10051 14 August 2015

AMENDED APPLICATION AND RESPONSE TO SUBMISSIONS BUILDING R1 BARANGAROO SOUTH (SSD 6513)

# ground floor plan

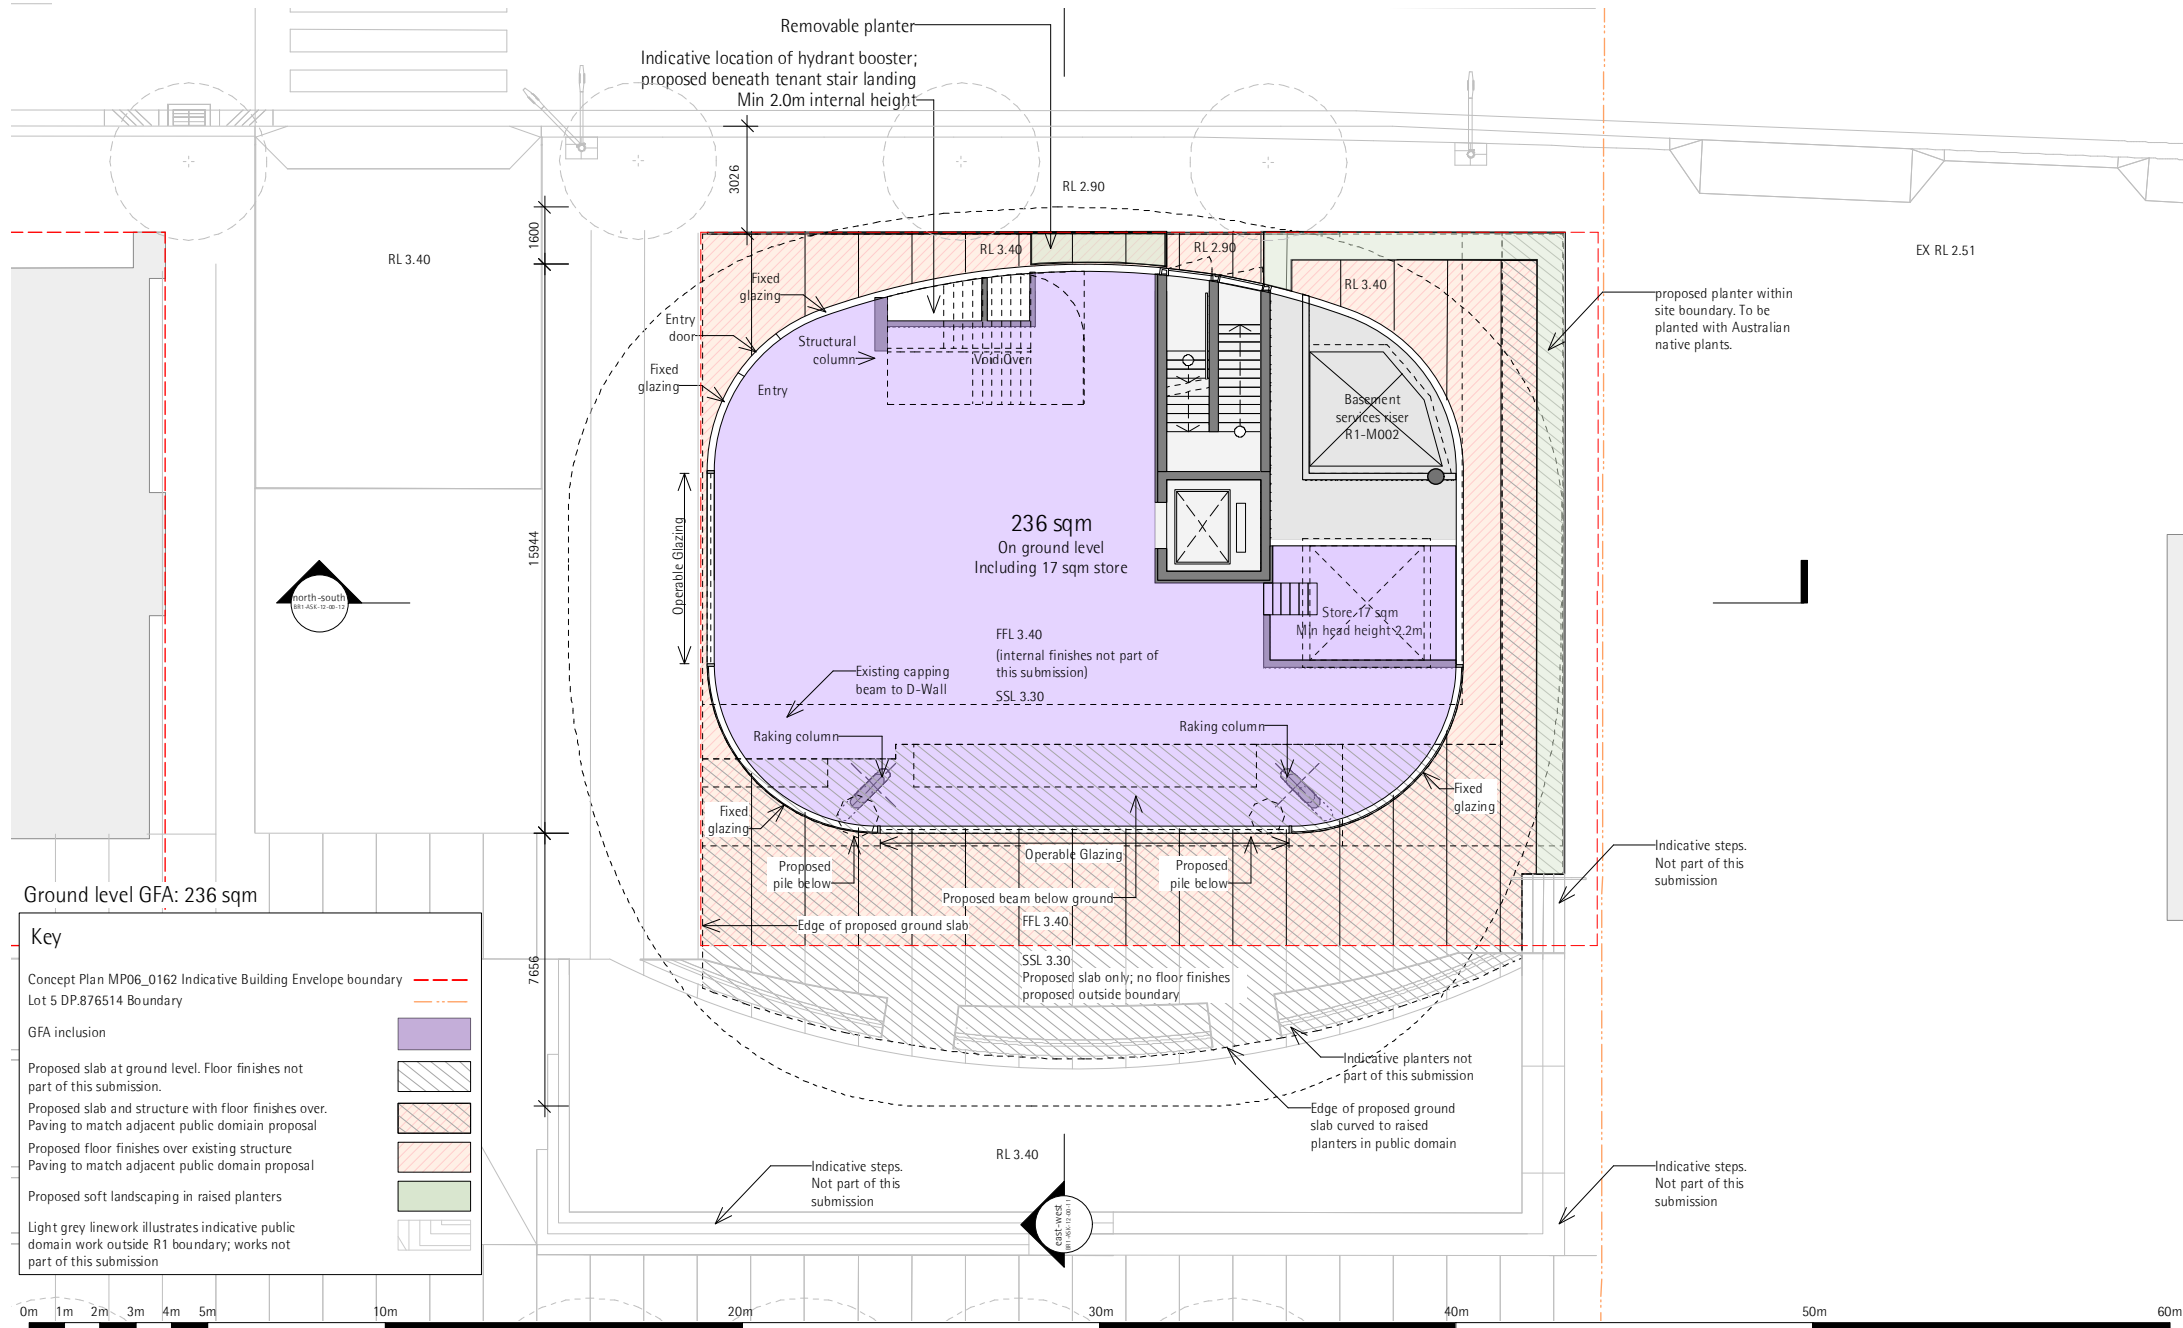
- provision of fit out details and identification of proposed use as a Pub (see further detail below);
- ground level amendments including modified planters, seating and steps to south and east, modified store room location, amended riser locations, provision of new meter enclosure and handrail and amendment of the north-eastern corner glazing to operable (see Figures 1 and 2);
- increased terrace area on Levels 1 and 2;
- additional void space on Level 1;
- revised void spaces on Levels 1 and 2;
- amendment to the curved operable glazing on Level 2;
- additional door added to the outdoor terrace on Levels 1 and 2;
- relocation of the wind break and revised planter and cladding on Levels 1 and 2; and
- roof structure revised as concrete.

section east-west

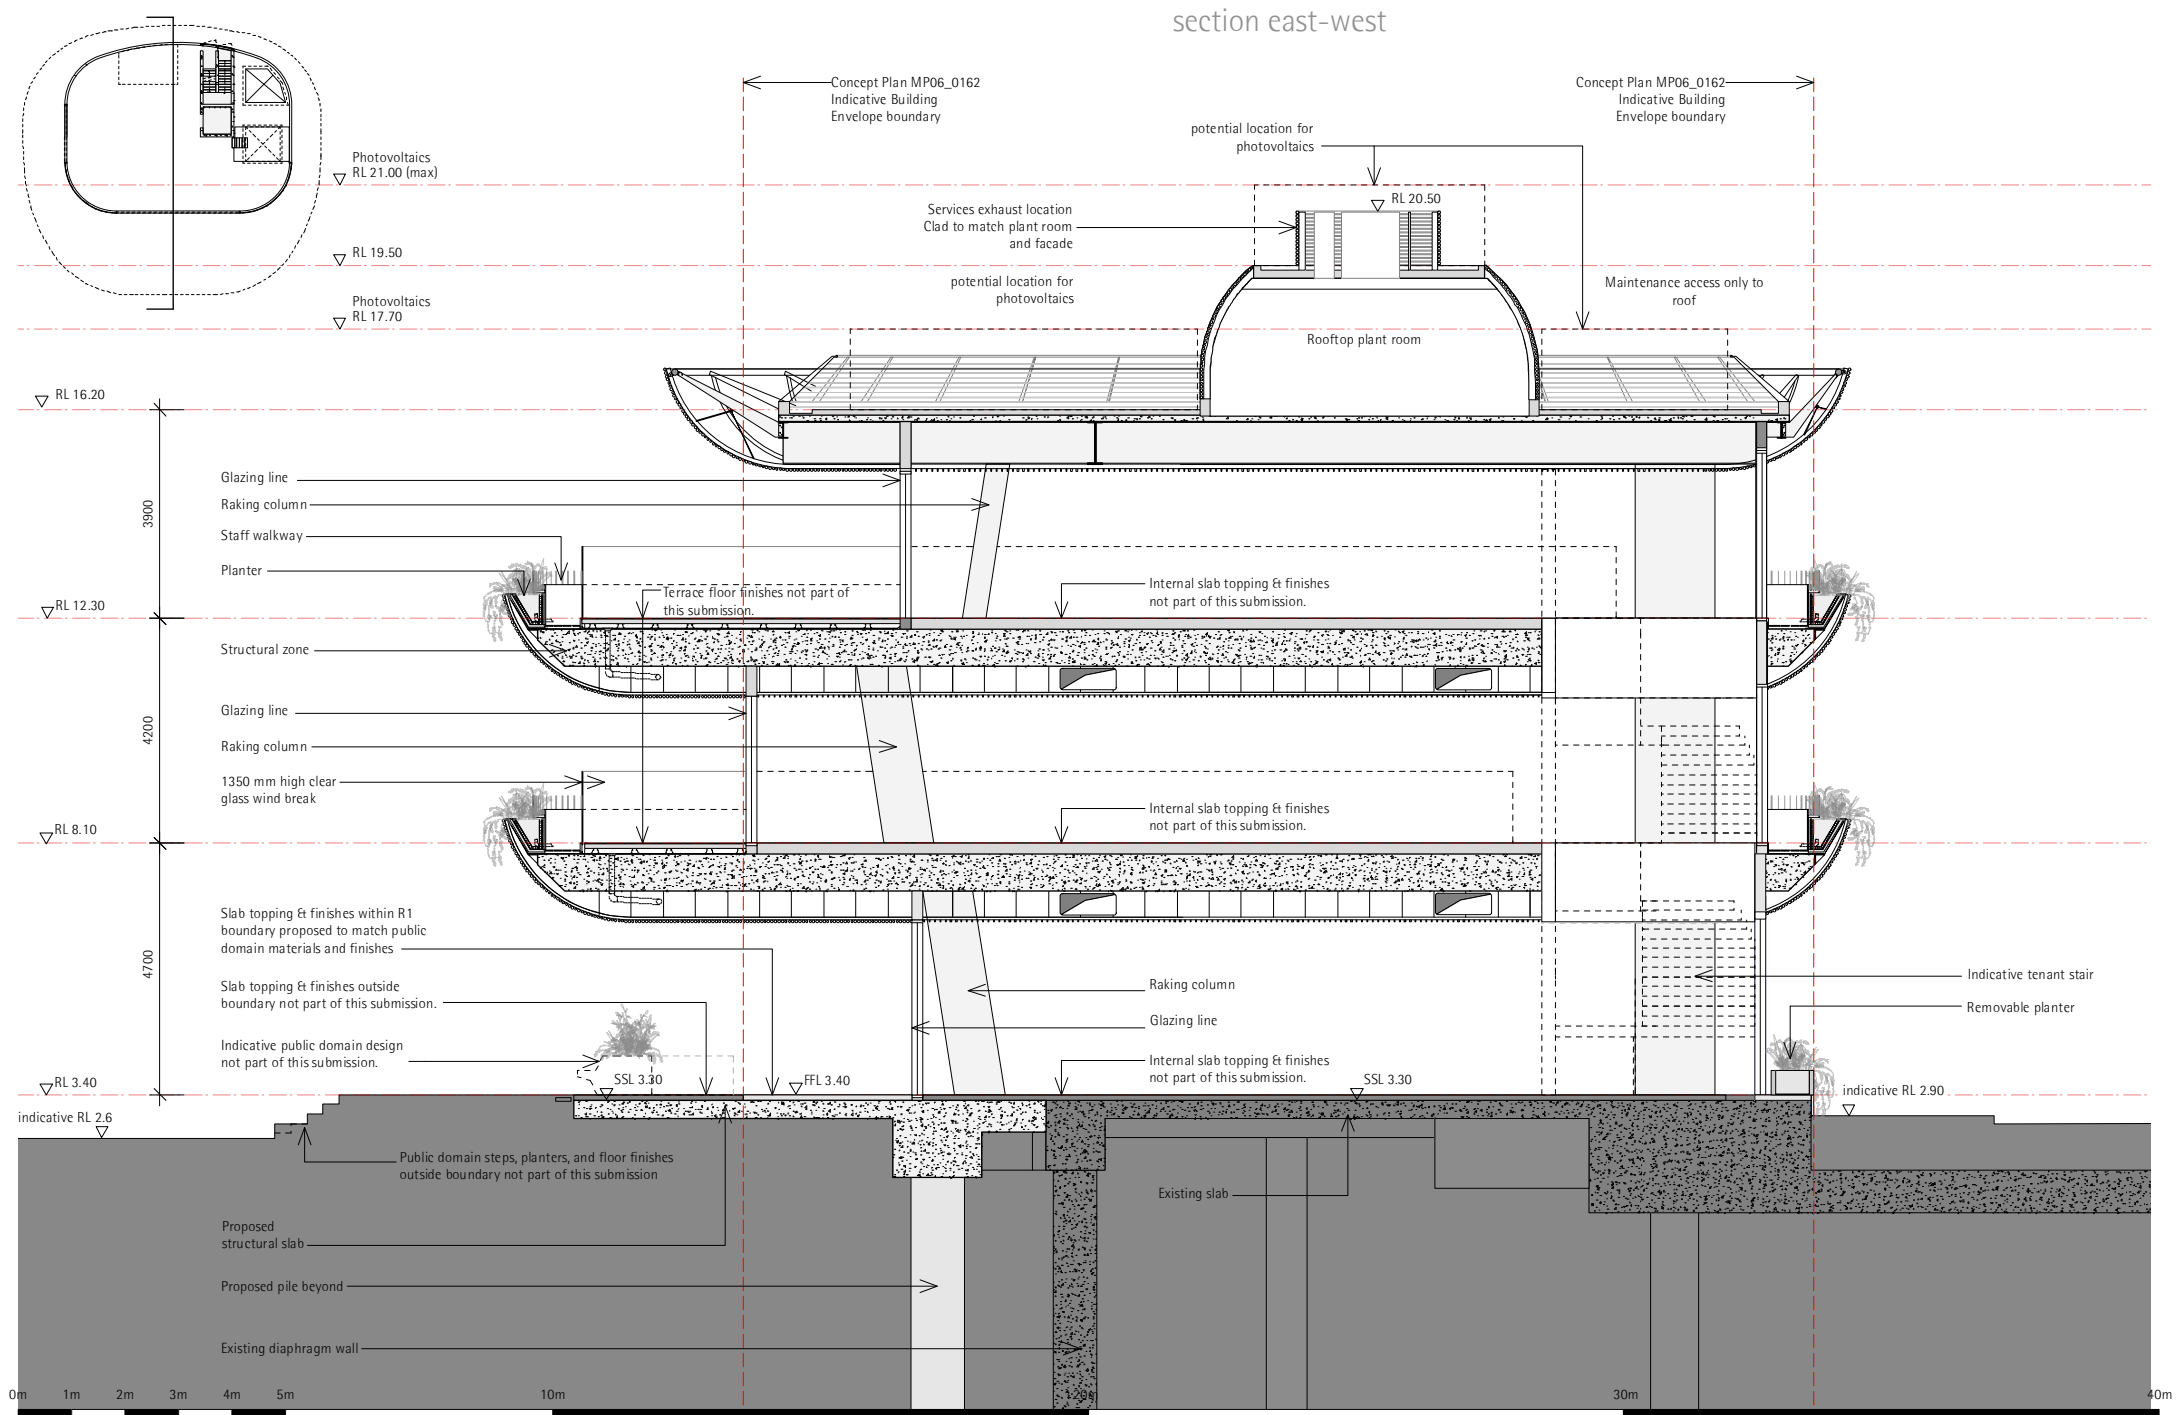
The Department has requested that the proposed variation to the indicative building envelope controls in the approved Barangaroo Concept Plan be addressed. The parts of the building that are proposed outside of the indicative building envelope in the Concept Plan are the proposed open terraces or overhang balconies that extend beyond the glazing line. The glazing line is contained within the indicative building envelope.

The extent of the overhangs is illustrated in Figure 6 below.

The overhangs represent a crucial part of the architectural design awarded from a competitive design excellence process. The proposal provides an appropriate design response by achieving architectural variety and interest to the southern gateway of Barangaroo. The overhangs offer outdoor seating amenity for a future food and drink premises; highly desirable to activate the public domain and take advantage of the waterside location.
